2190460

## Response to Submissions

### 89 John Whiteway Drive, Gosford – SSD 10362

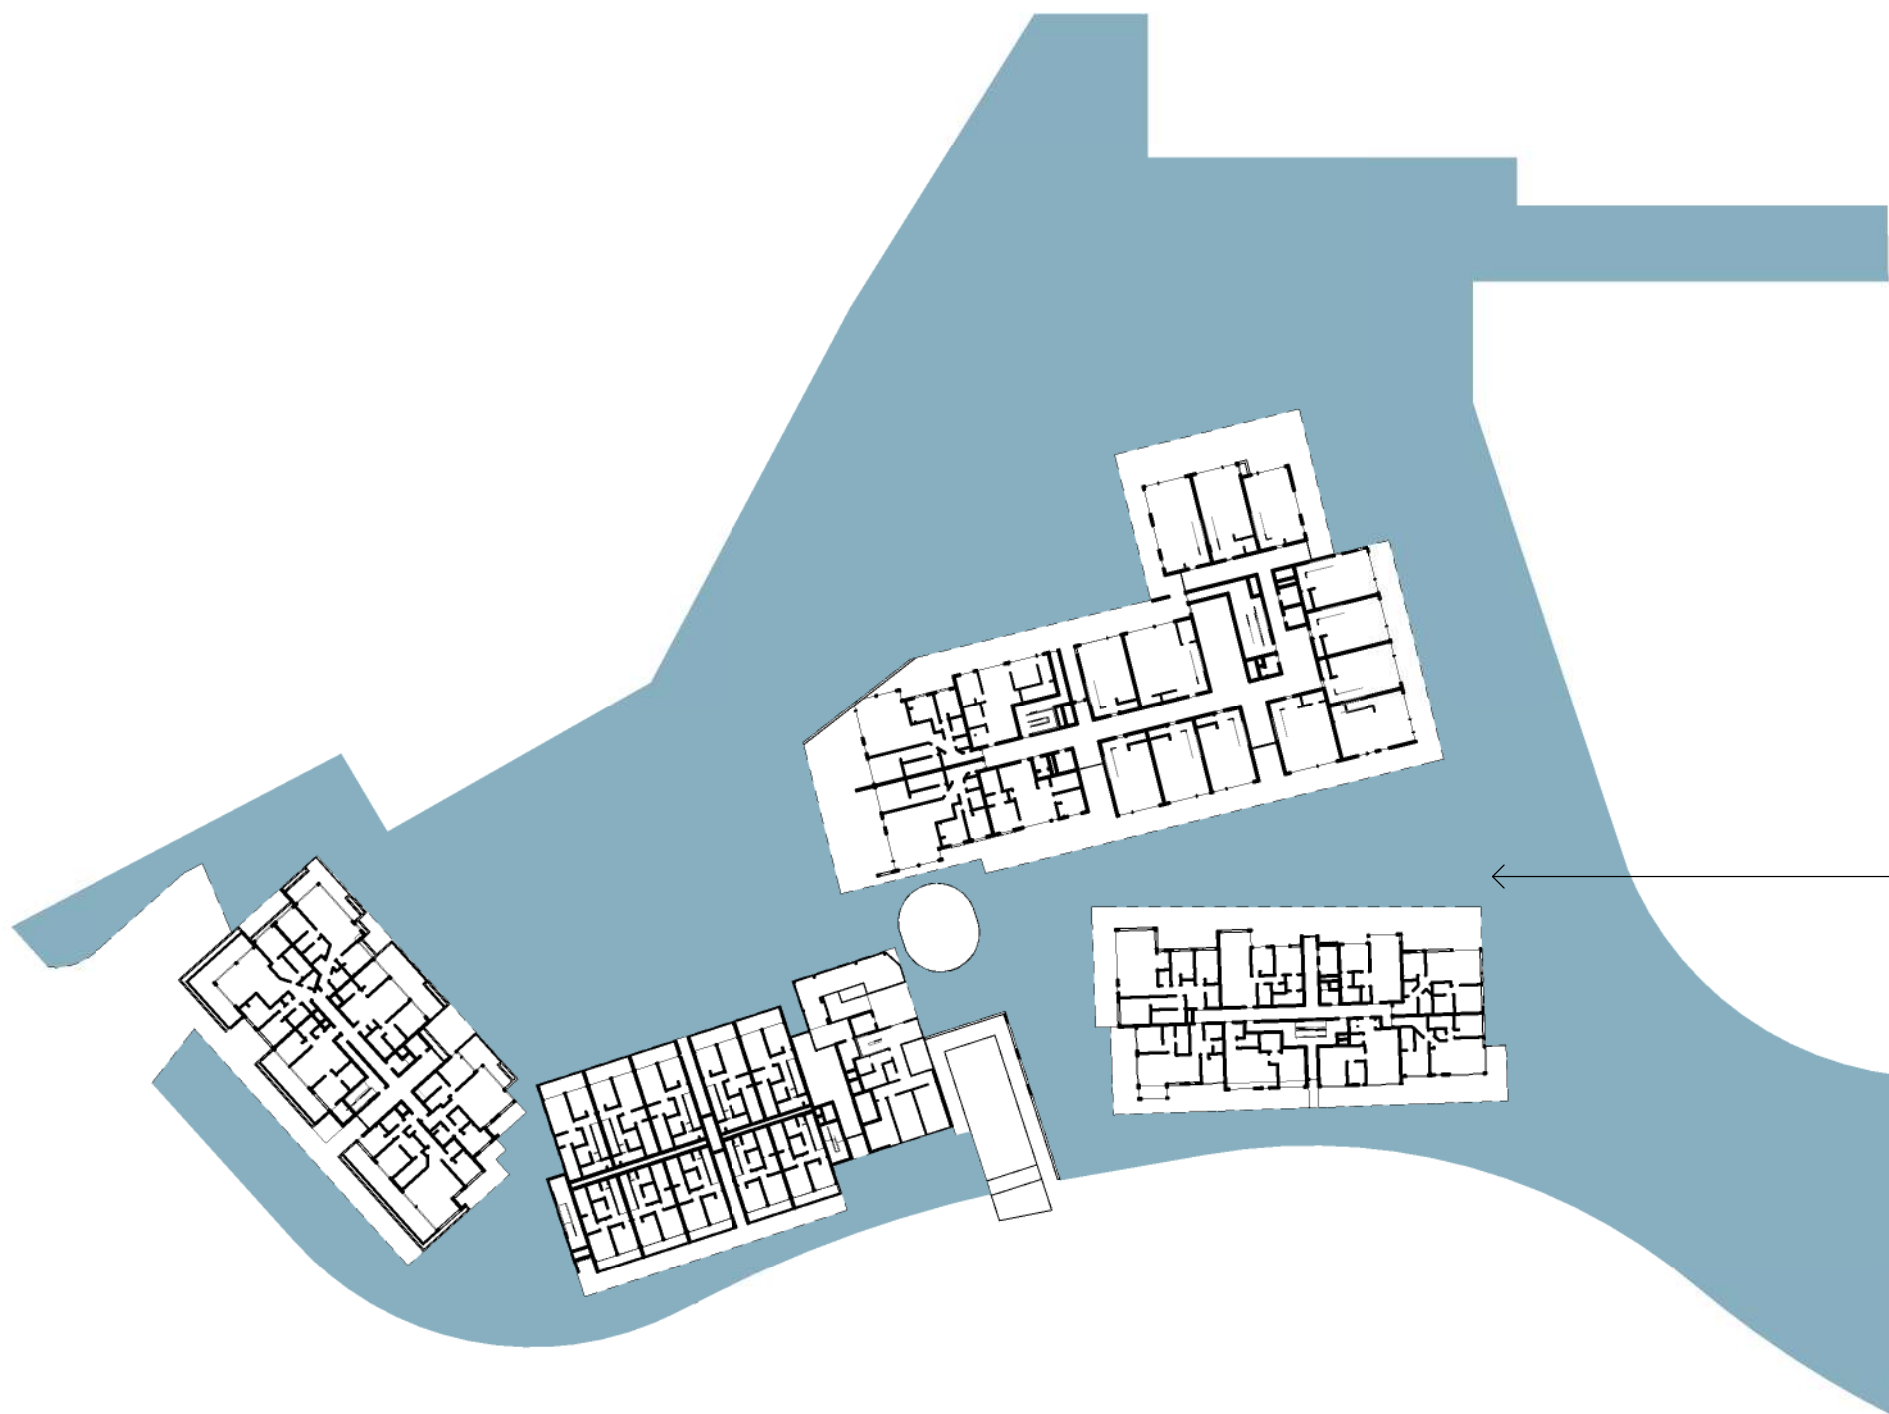
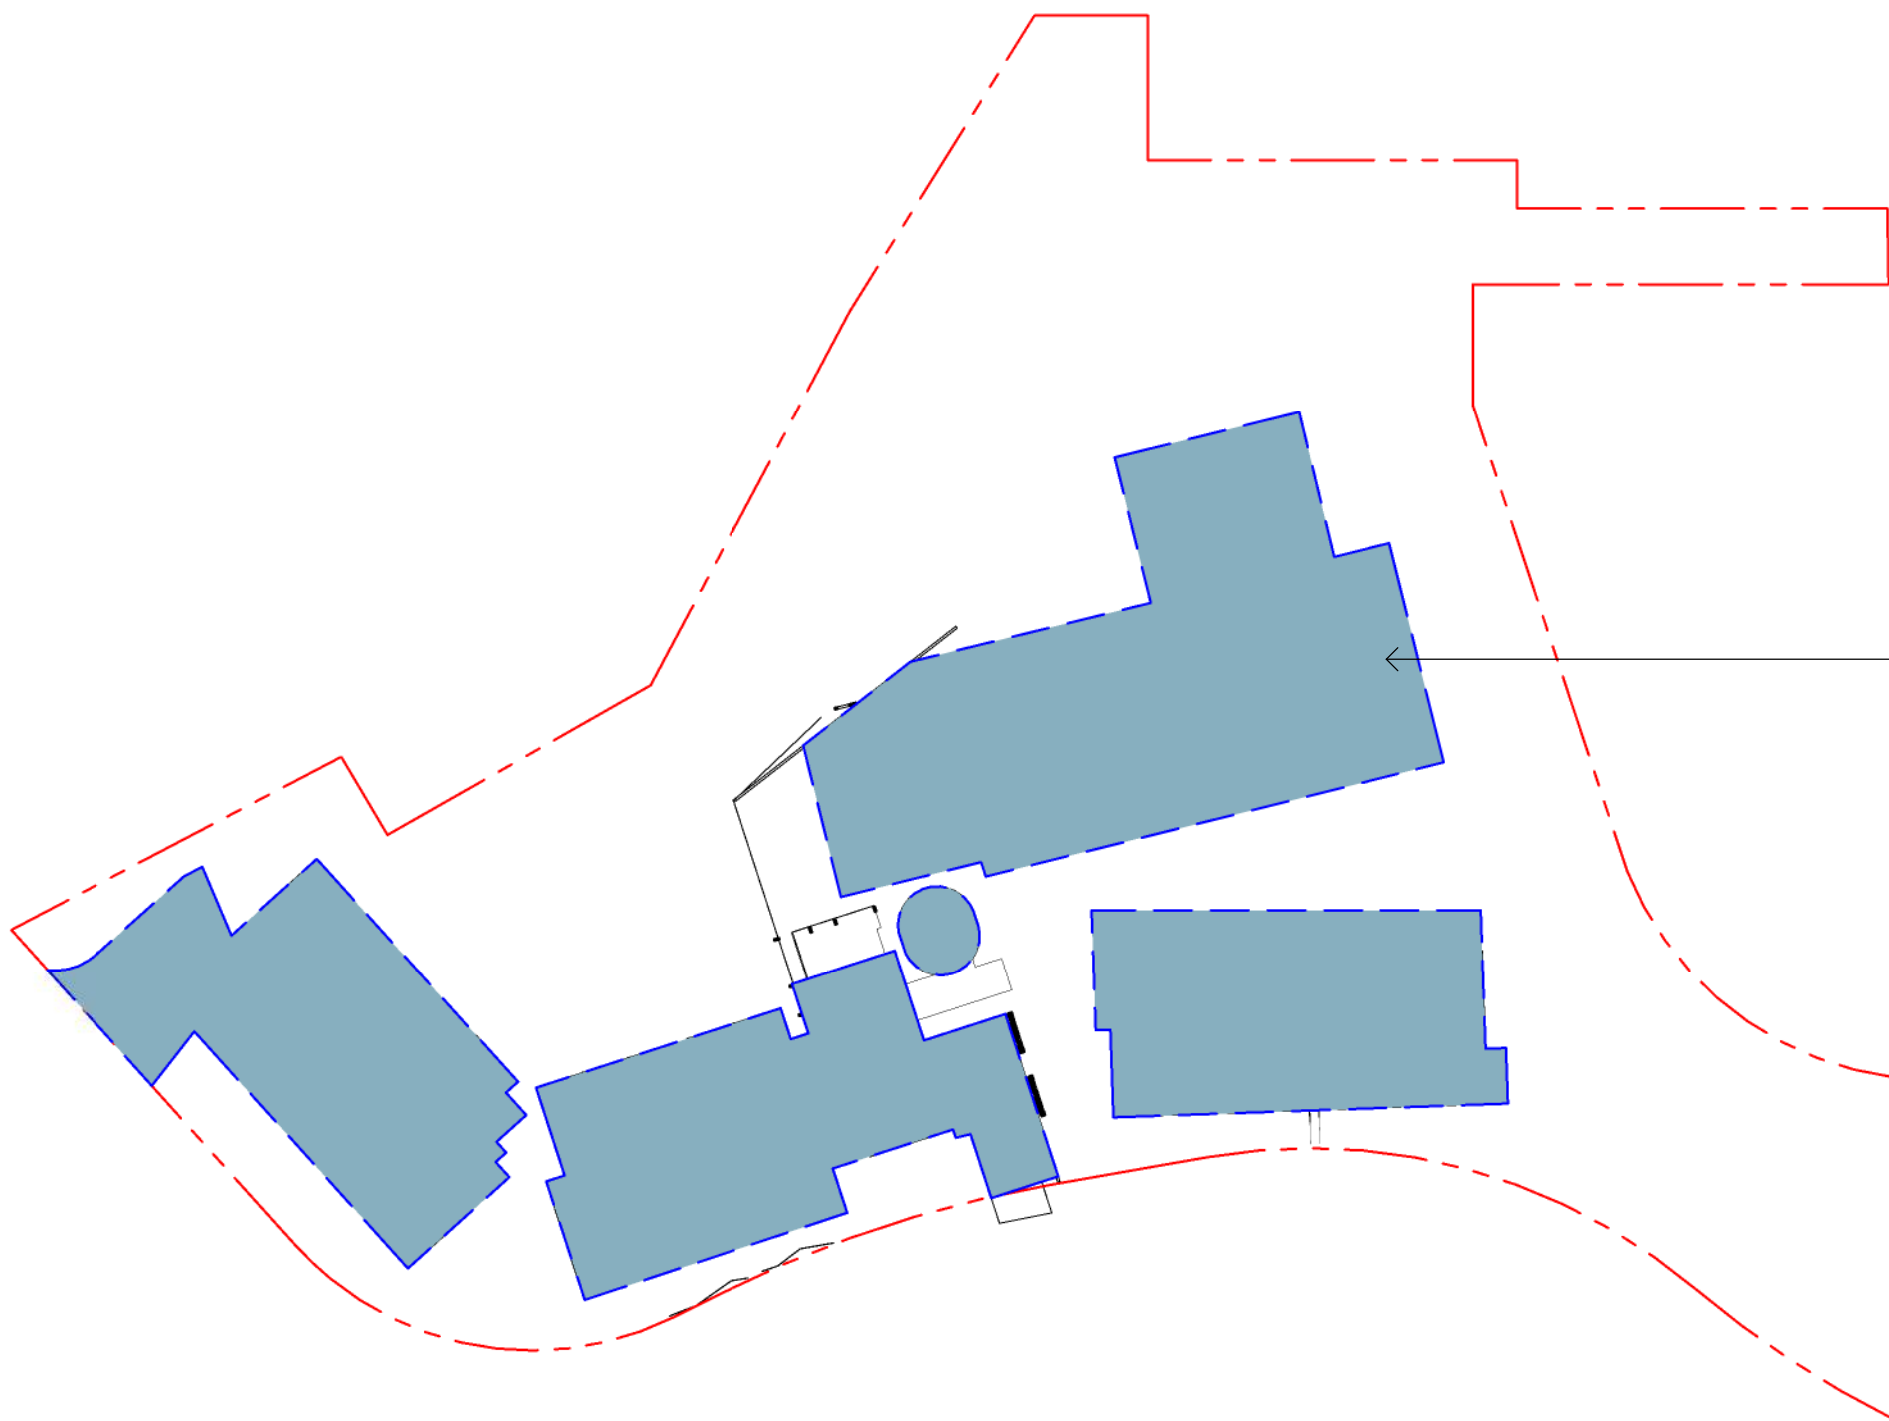
<p>Please clarify whether the areas highlighted in yellow (Drawing No. DA001.4B) are included in the calculation of communal open space in addition to the areas shown hatched.</p>	<p>See additional Common open space diagrams provided by ADG at DA0001.4C which delineate common open area.</p>
<p><b>Natural cross ventilation</b> The ADG states that for an apartment to be considered cross ventilated, most of the primary living space and n-1 bedrooms (where n is the number of bedrooms) should be on a ventilation path. Single-aspect unit types, such as C1-02 and C1-03, do not appear to meet the ADG definition for cross ventilation. Please address cross ventilation for single aspect unit types.</p>	<p>Natural Ventilation diagrams have been amended at DA006.8 – DA006.11.</p> <p>The proposal achieves 60.8% natural ventilation overall across the development, which achieves the 60% ADG Design criteria.</p>

GFA CALCULATED AREAS:

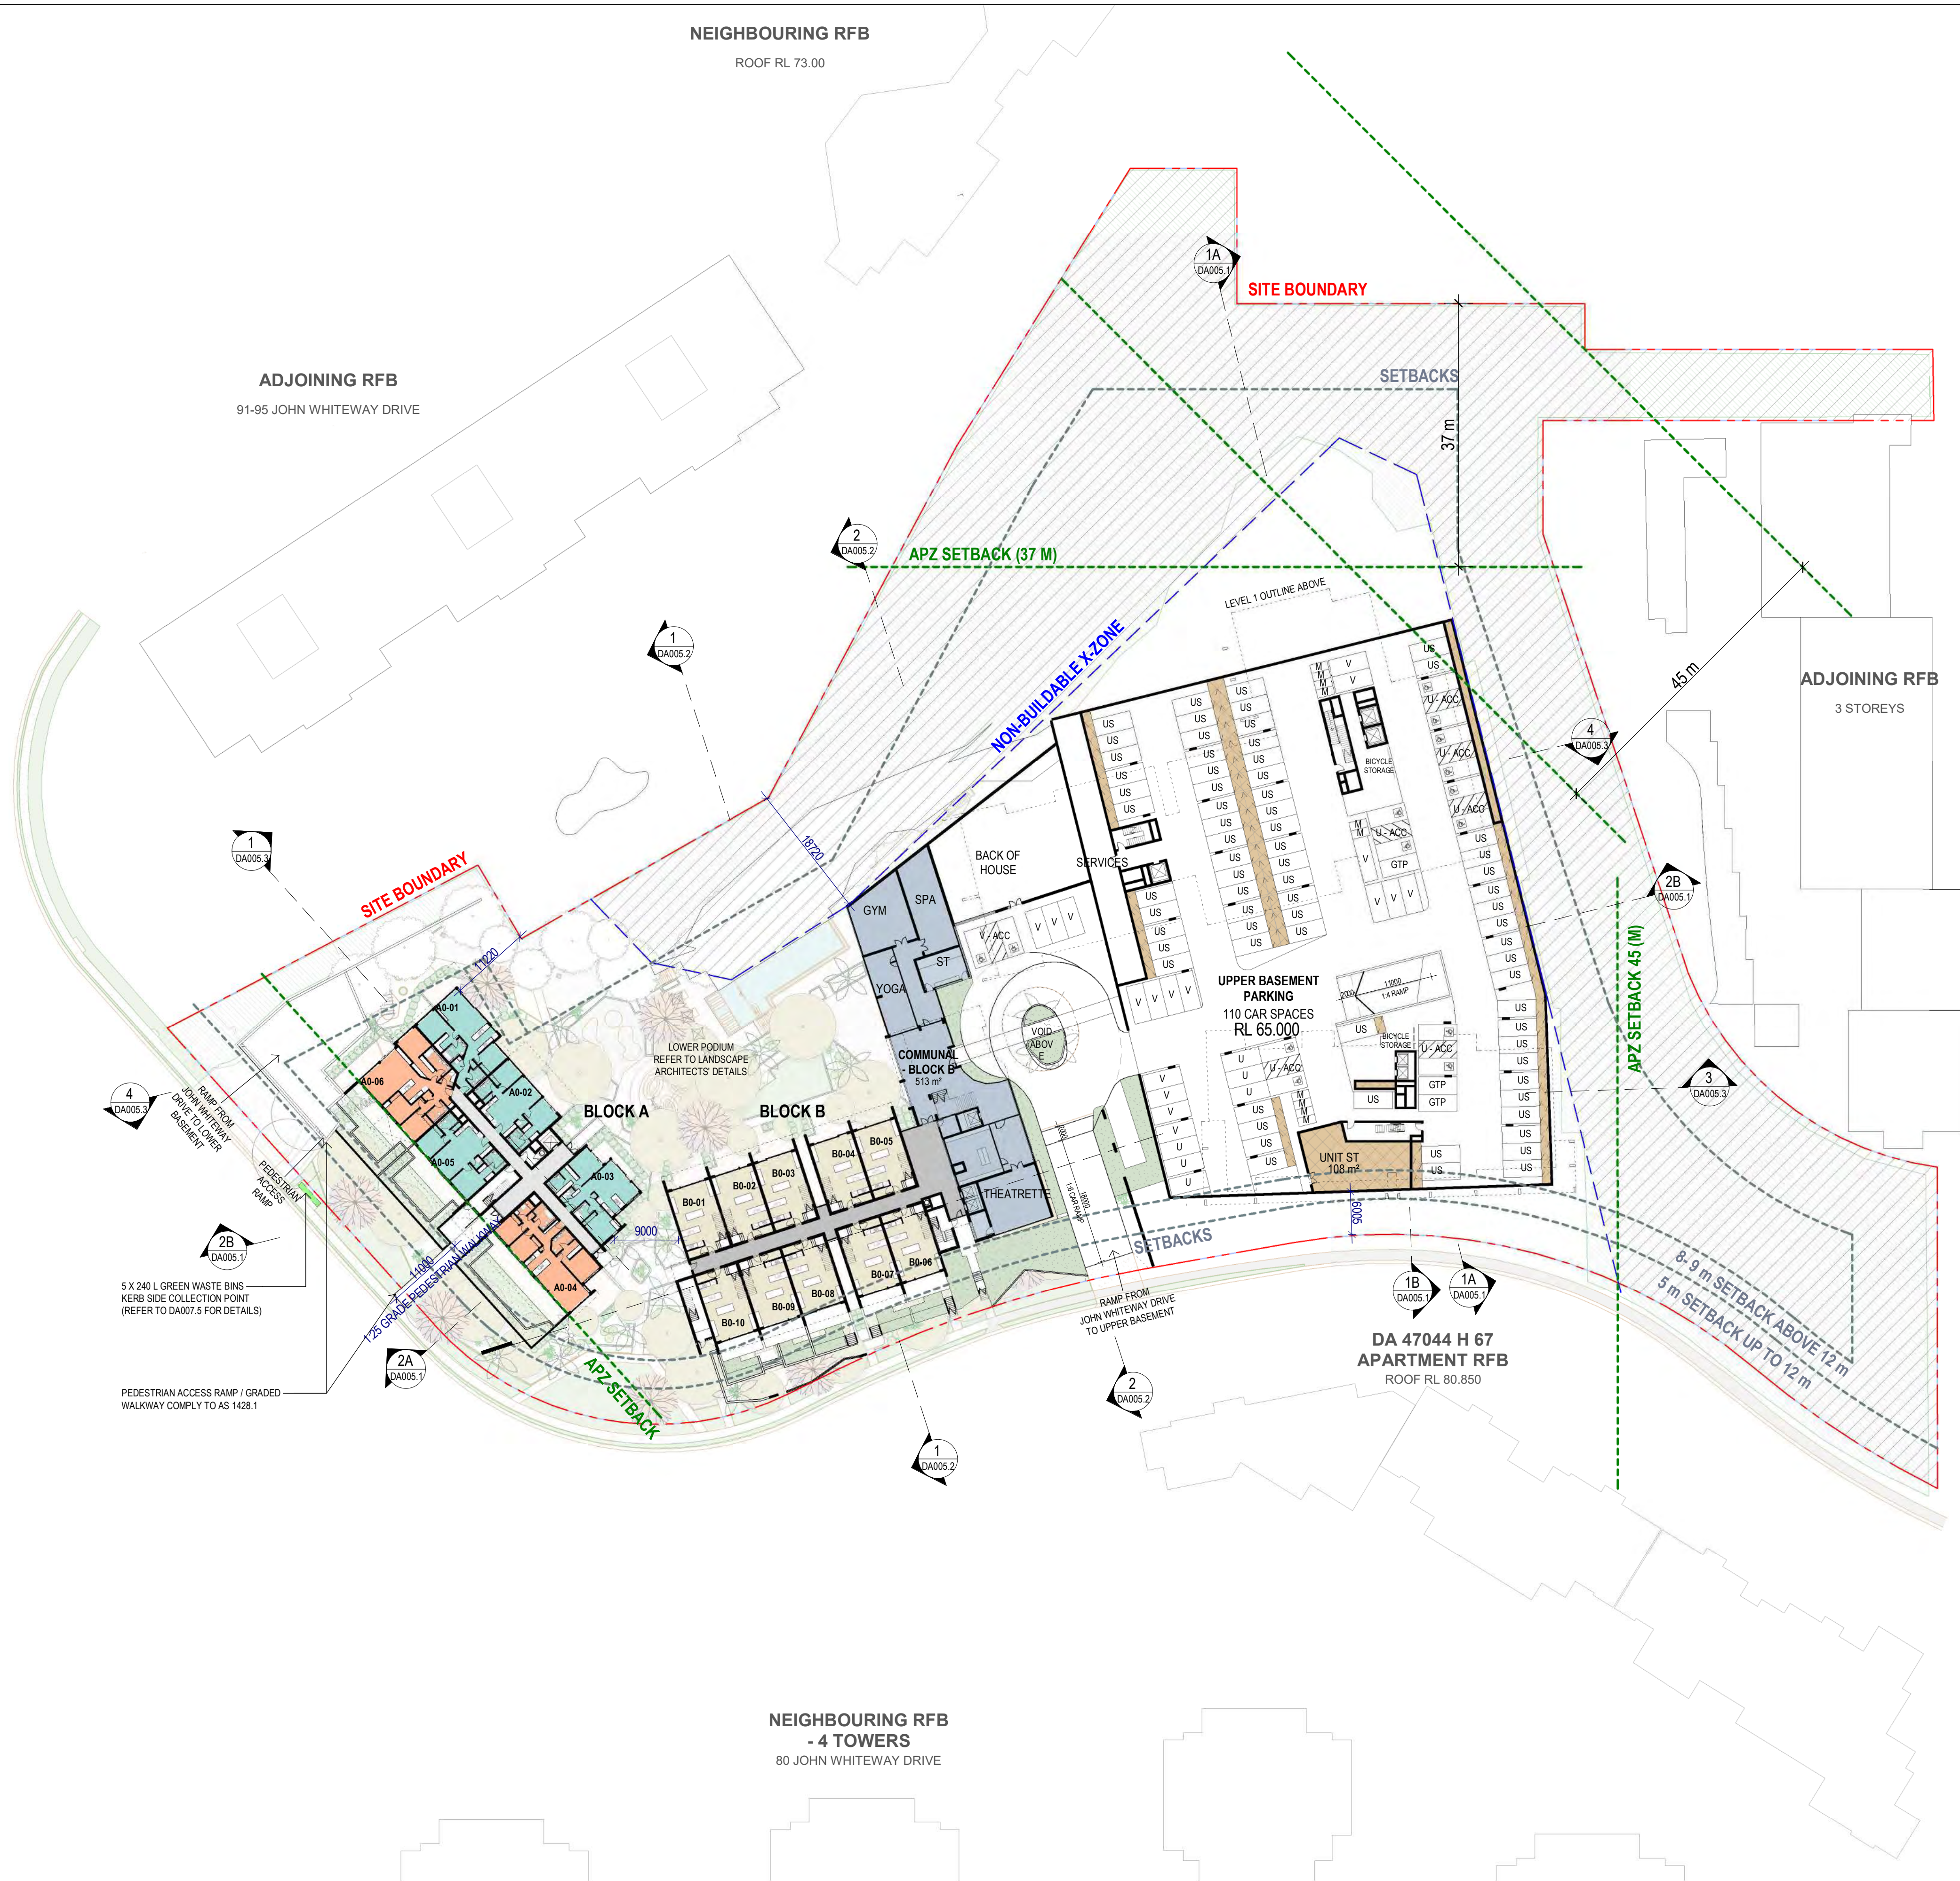
<p><b>GFA calculation plan</b></p> <p>Please confirm which areas are excluded from GFA. Based on the detail provided it is unclear whether all areas indicated in white have been excluded from the calculated GFA.</p>	<p>See GFA diagram provided by ADG- DA007.2A- DA007.2C</p>
<p><b>Access to Block D</b></p> <p>Vehicle access to Block D seems to be provided at basement level only. Please clarify the access arrangements for emergency vehicles, deliveries and removalists to Block D.</p>	<p>See Circulation Access diagram at DA007.2D.</p> <p>The primary loading dock for large removalist type vehicles is in the loading area. From this location access to all blocks will be via the basement. The property will have a small trolley / tractor to pull small loads as necessary. The building will operate a on-line booking system for residents managed by the building manager to coordinate resident move in / out to manage as appropriate.</p> <p>Emergency vehicles may access all blocks from John Whiteway Drive via the on-street entries.</p>
